From: [Nelson, Jennifer L \(DFW\)](#)
To: [Zach Torrance-Smith](#)
Subject: RE: SP-24-00005 Mohar - Notice of Application
Date: Friday, April 12, 2024 4:53:51 PM

Subject: SP-24-00005 Mohar - Notice of Application

CDS is requesting comments on the following short plat application: SP-24-00005 Mohar.
Links to the file materials can be found below. The comment period will end on **April 18, 2024, at 5pm**. CDS will assume your agency does not wish to provide comment if not received by this date.

MOHAR FARM SHORT PLAT

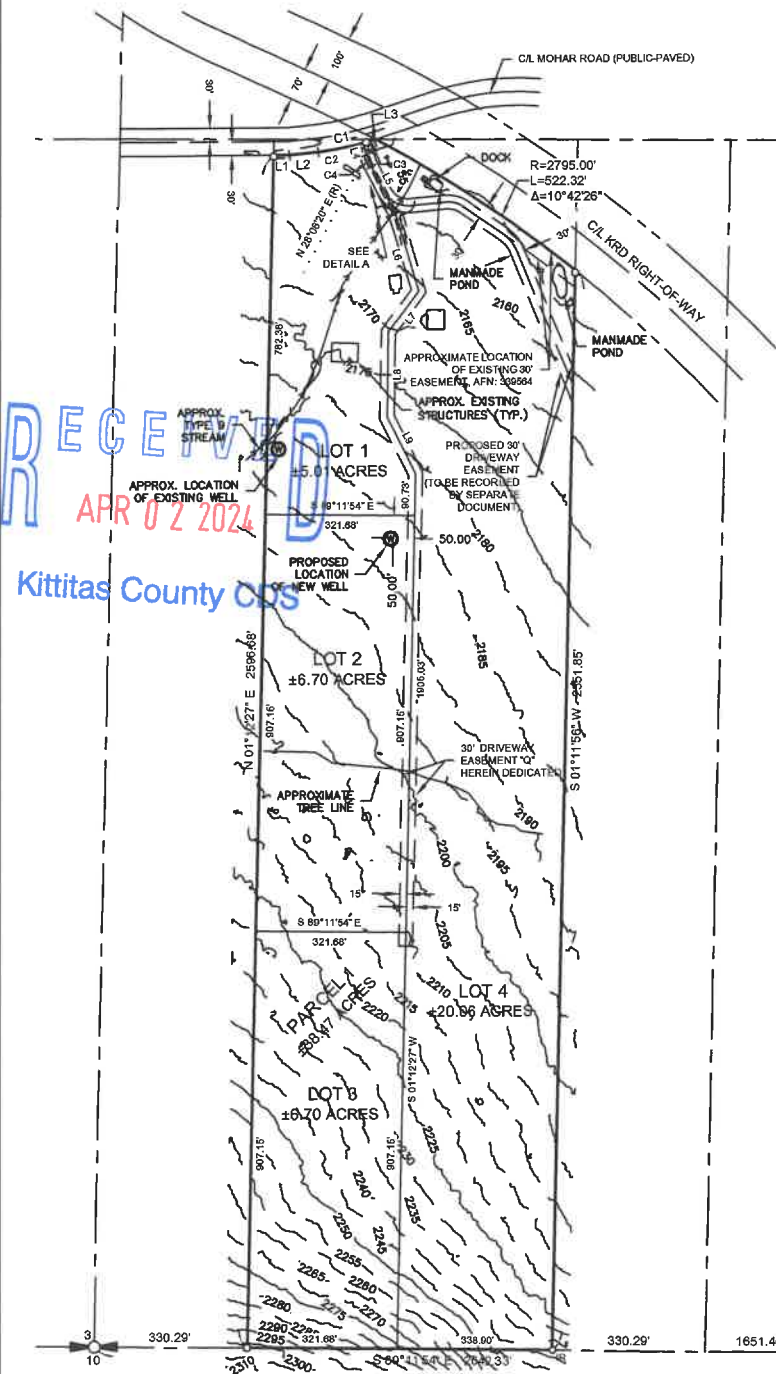
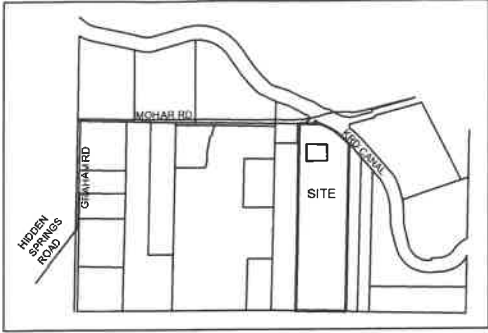
Thank you for the opportunity to comment. Prior to any ground disturbances on these parcels, we recommend a complete critical areas study be completed to ensure there are no impacts to the functions and values of the critical areas. We would welcome the opportunity for a site visit to better understand the stream on site. It is possible that an HPA would be required for any work associated with the driveway/road easement improvements.
